**Consultation Response from Chris Bembridge KC,
Highways Development Management**

**2022/93938 First and Second Floors, Shopping Precinct, New Street and Albion Street,
Huddersfield, HD1 2TR**

**Change of use from A1 (business retail and storage) to C3 (residential) 18 studio flats at first
and second floors and external alterations**

Date Responded: 05/12/23

Proposed Second Floor Plan

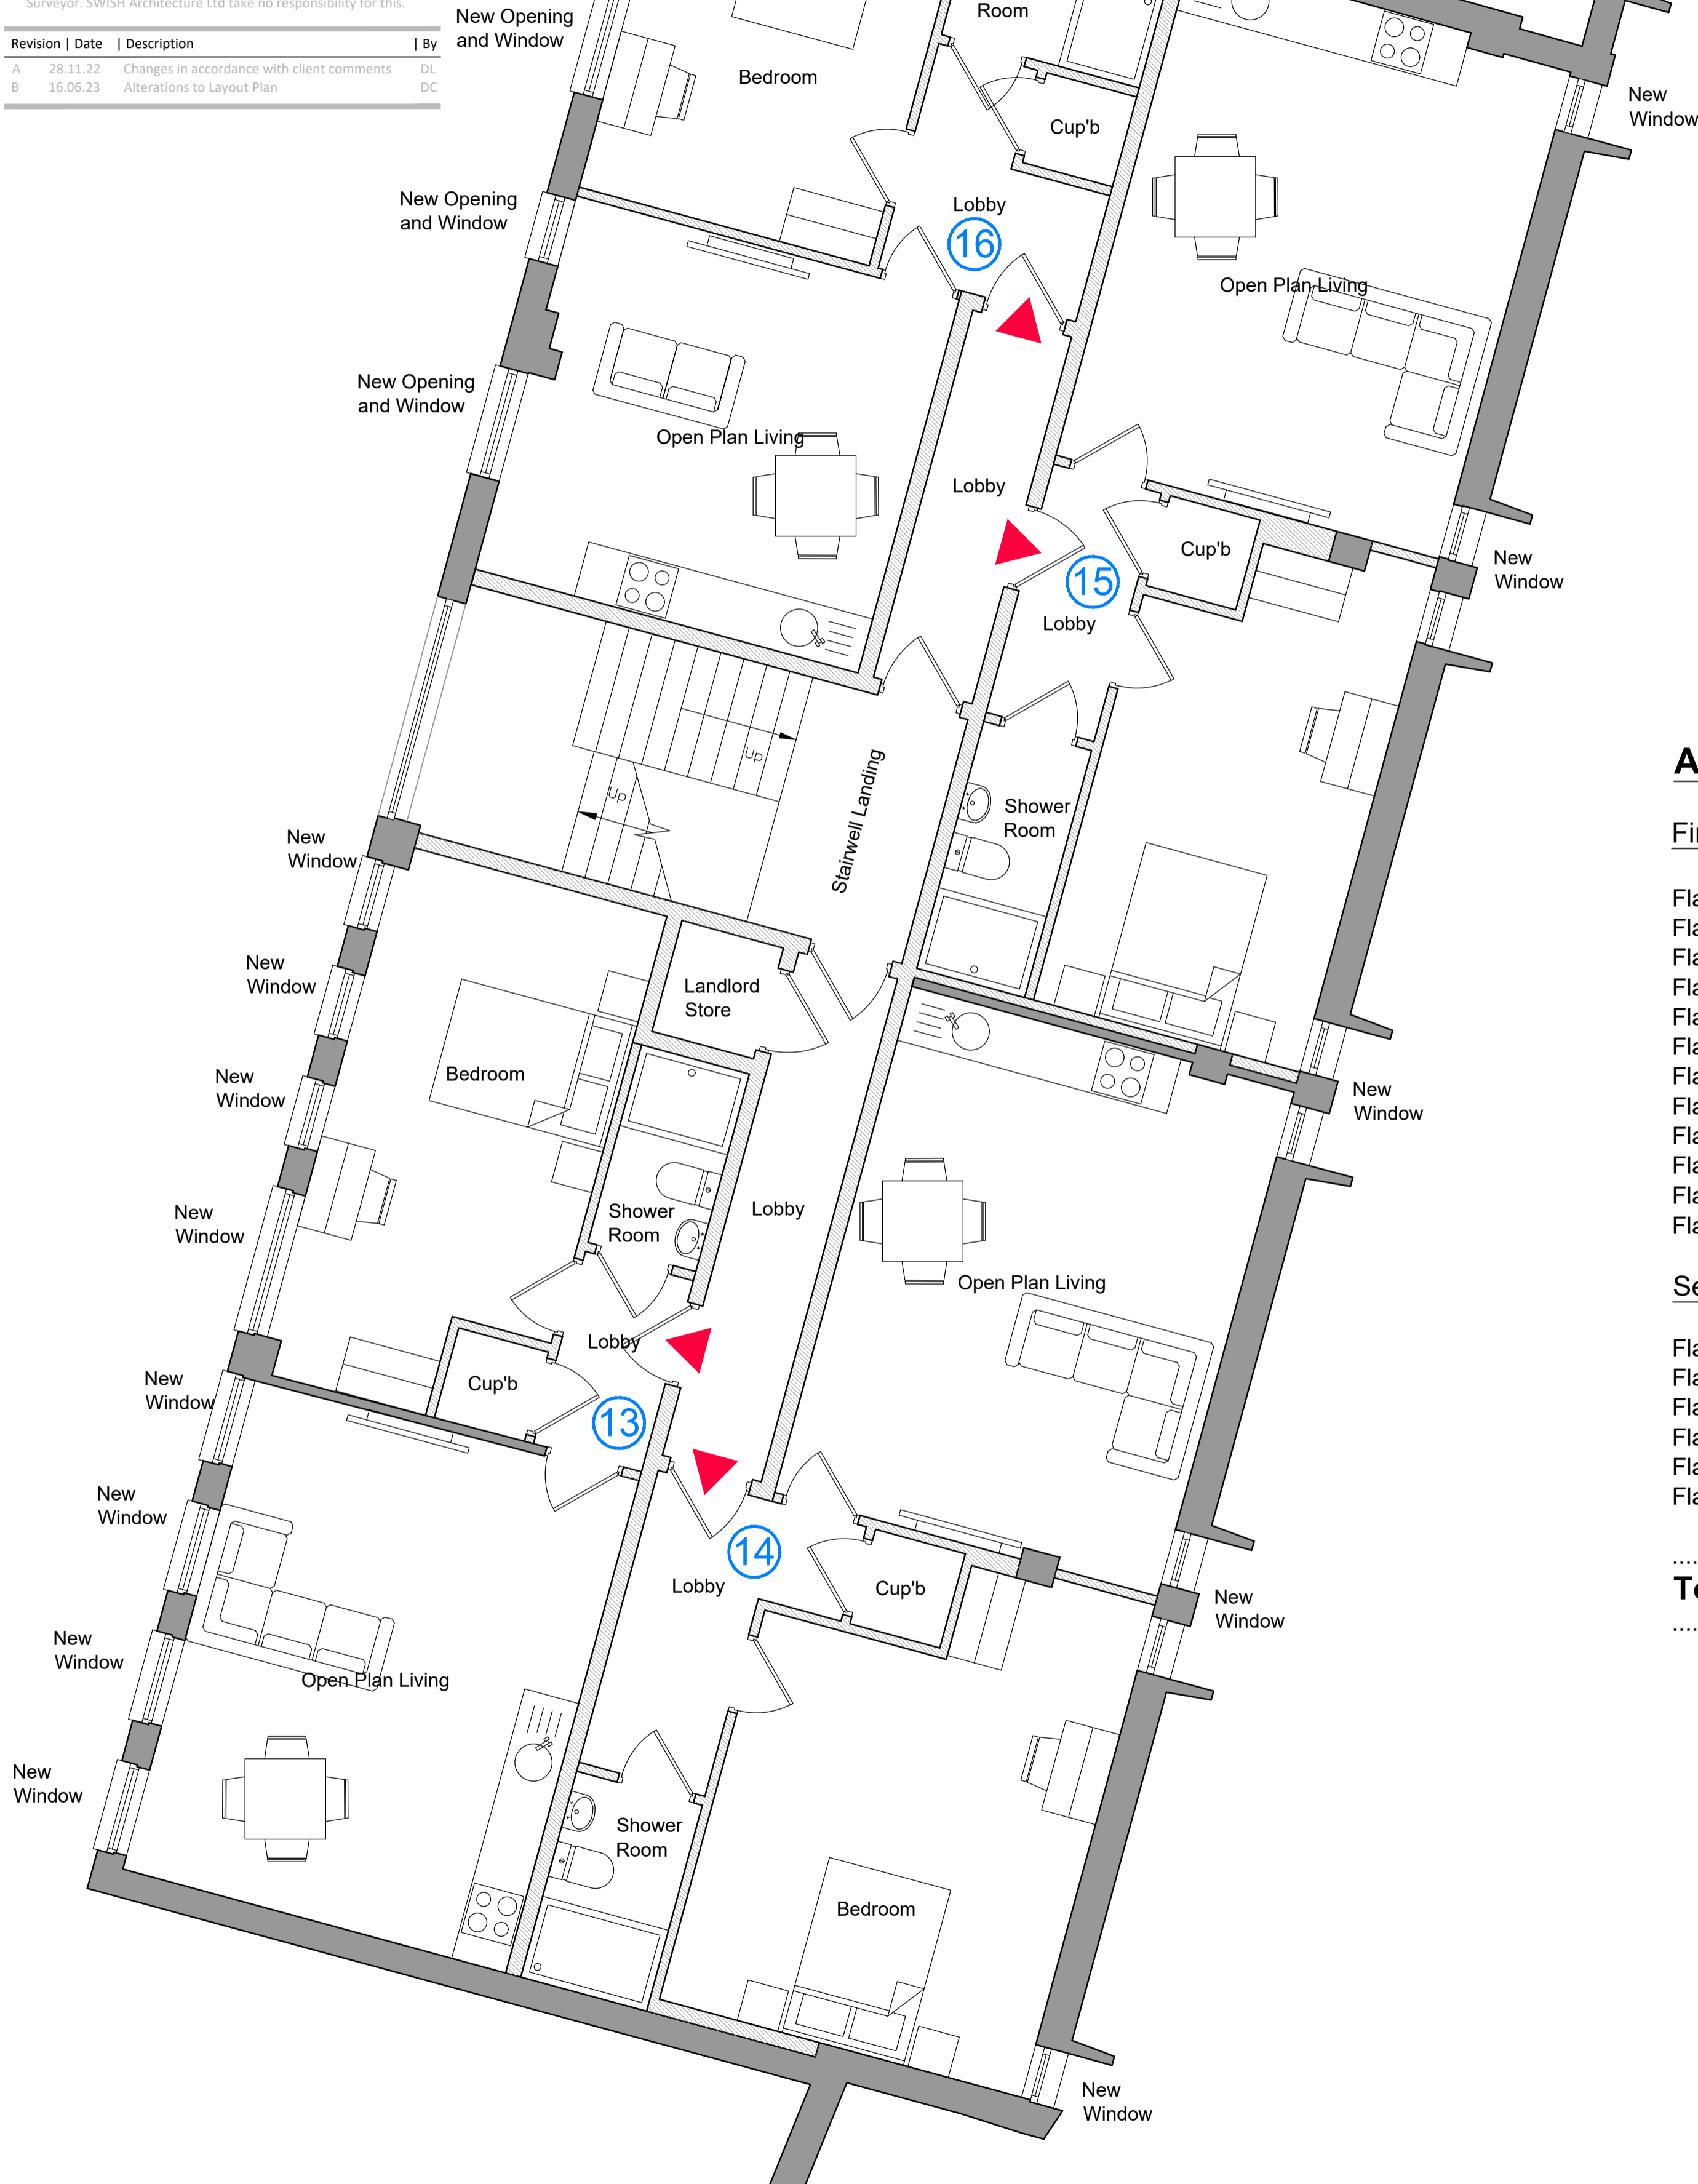
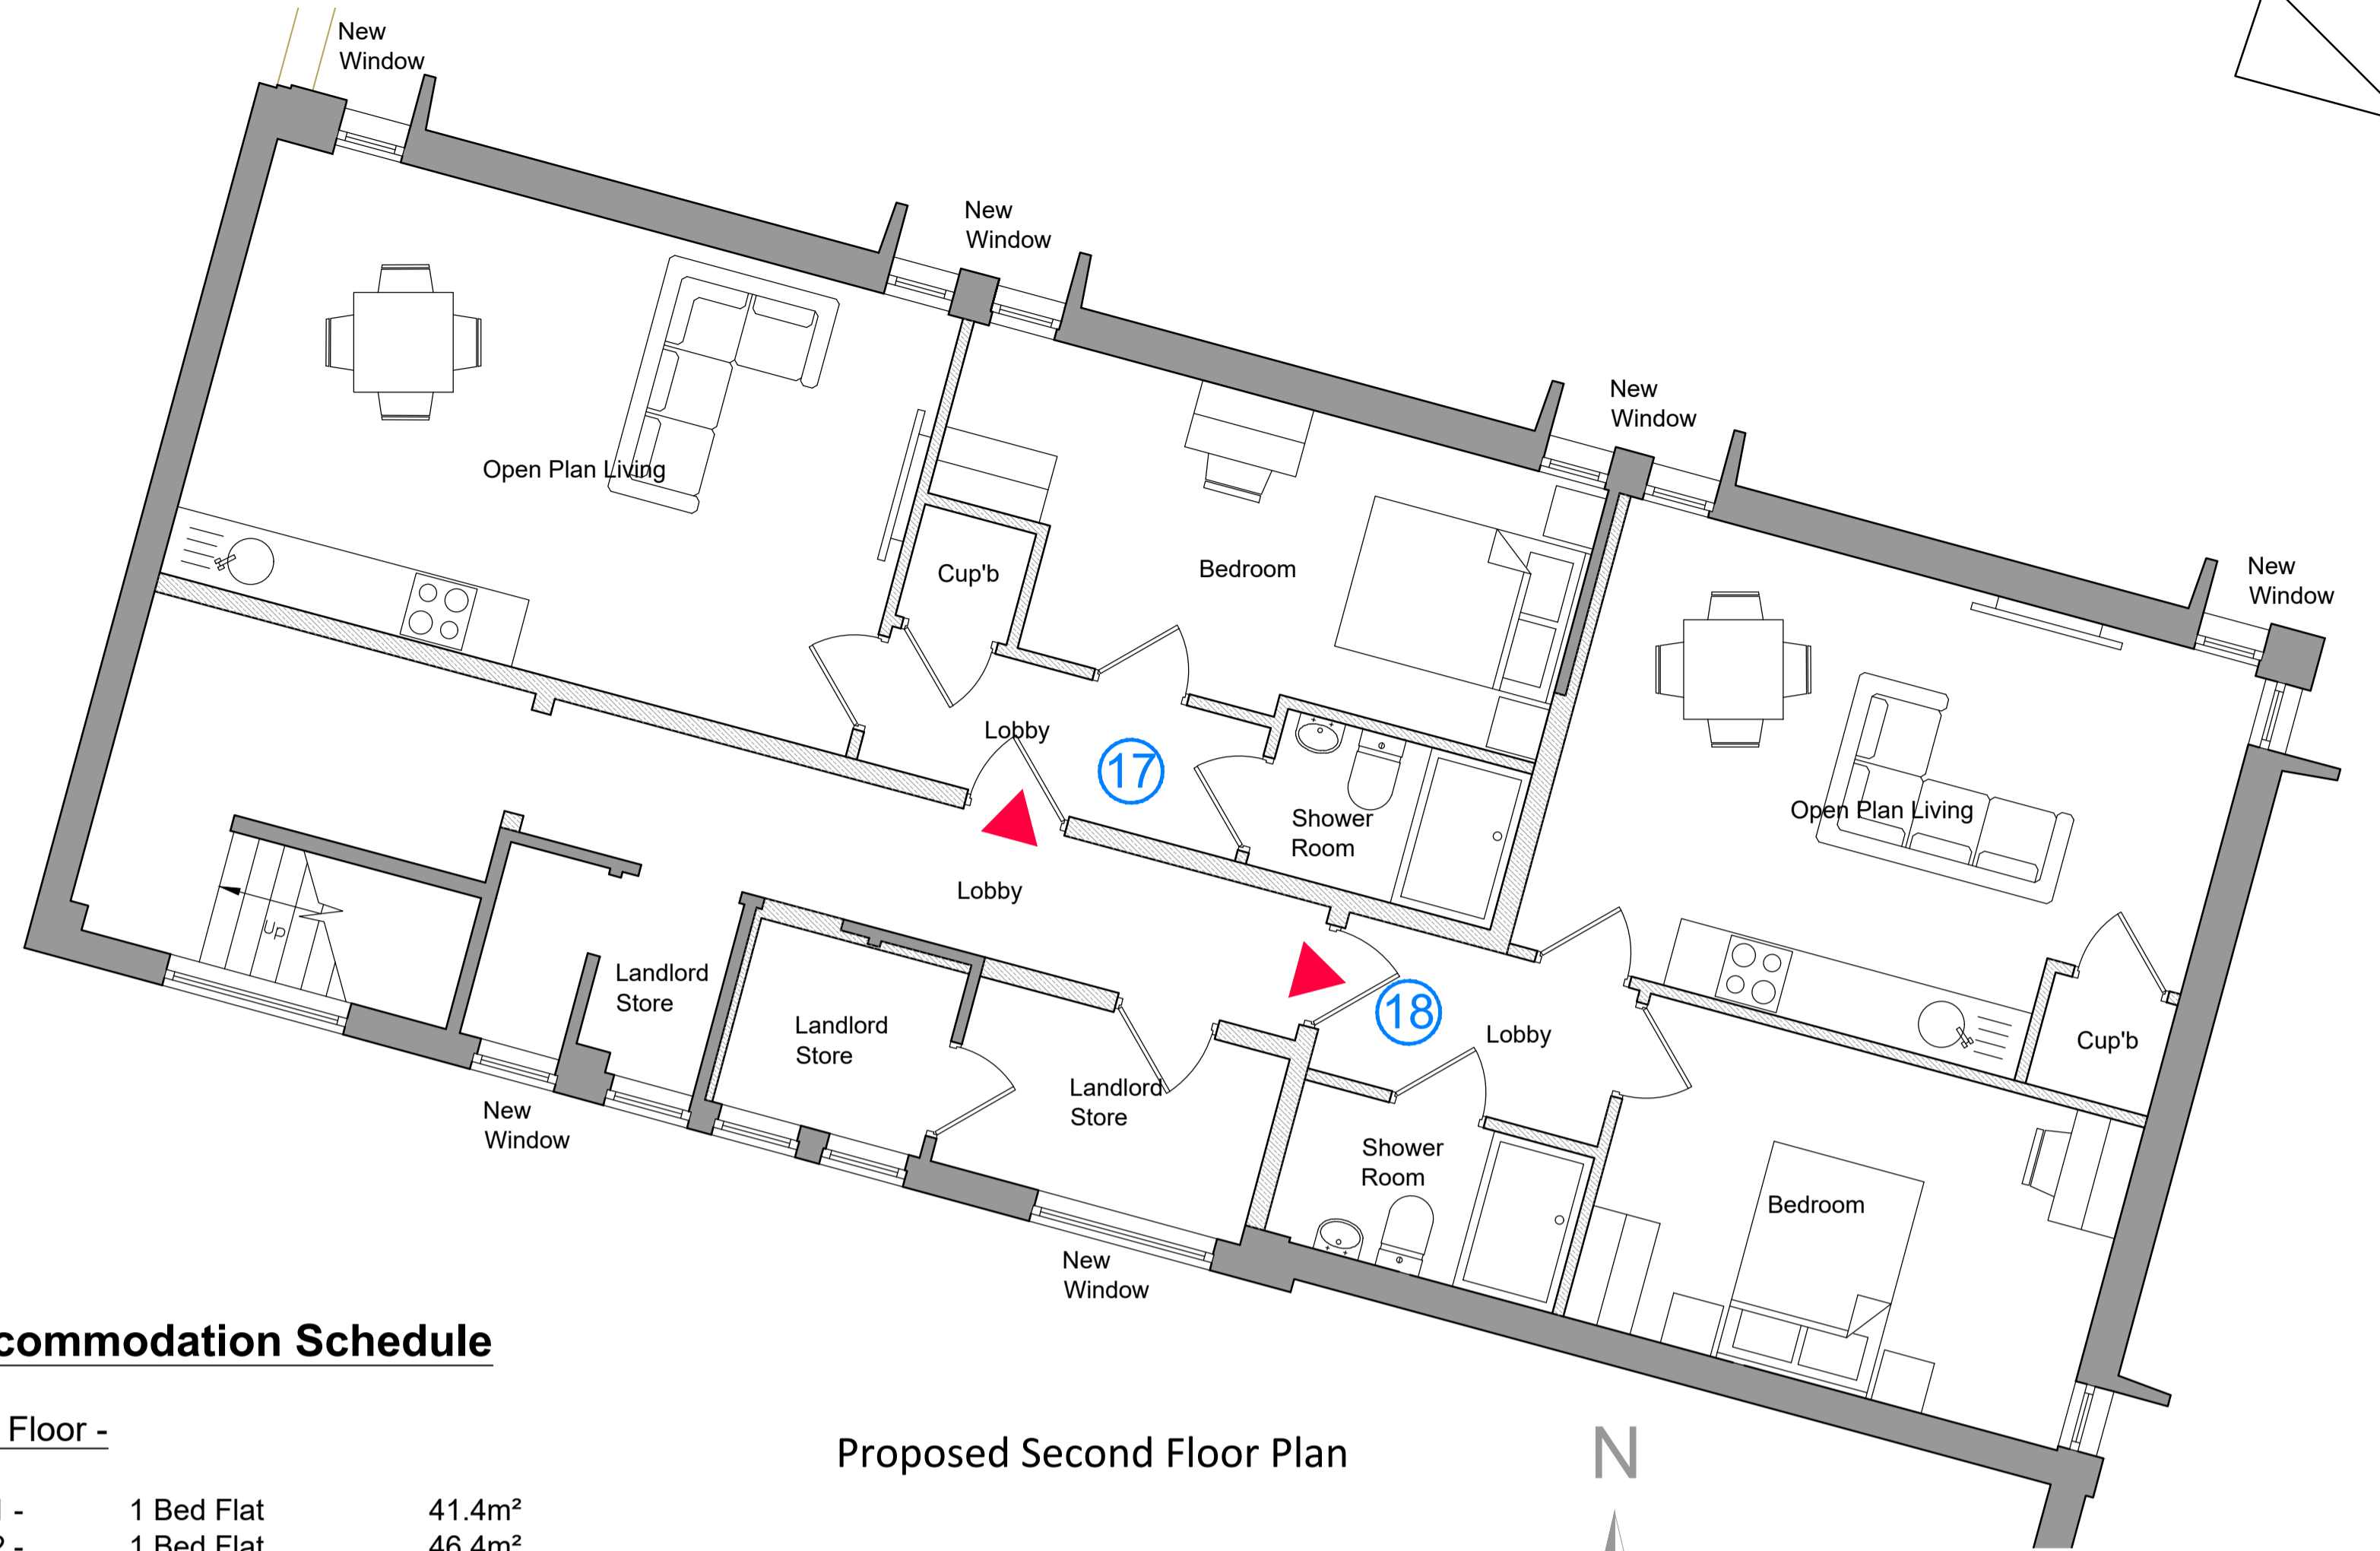
The cycle storage is located on the first floor or the northern half of the site, this has no direct internal connection to flats number 1 to 8 on the first floor and 14 to 16 on the 2nd floor, this is just over half of the flats with no direct access to the cycle store. We feel that the design is ill thought out and quite poor and the sustainable travel element of the development has come a long way behind other constraints and as such does not fit in with Kirklees policy on the promotion of sustainable travel choices, and this is very disappointing.

A possible improvement to cycle parking would have been to have communal access to the cycle store from the first floor decked car park accessed from Albion Street through the existing doors (may need improvement for cycle access), with a further pedestrian door accessing the southern half of the development from the car park, this would enable cyclists from the whole development to access the cycle store without the need to use a narrow staircase and have to walk around the outside of the building to then access their flat. We are unsure if the access across the car park would be available, we asked for details of the relationship with the car park and the development previously but received no reply on this.

No details of the cycle storage were provided with the revised plans beyond the location of a room. No details of cycle rack or mounts so that cycles can be securely fixed were provided. Without adequate levels of security, the cycle storage will not appear attractive to cyclists to leave their cycles and again would dissuade residents from using sustainable active modes of travel, again against Kirklees policy.

If the cycle storage is to be accessed via the northern stairwell, then a cycle gutter should be included within the stairwell so that cycles can be wheeled up the stairs rather than carried or dragged.
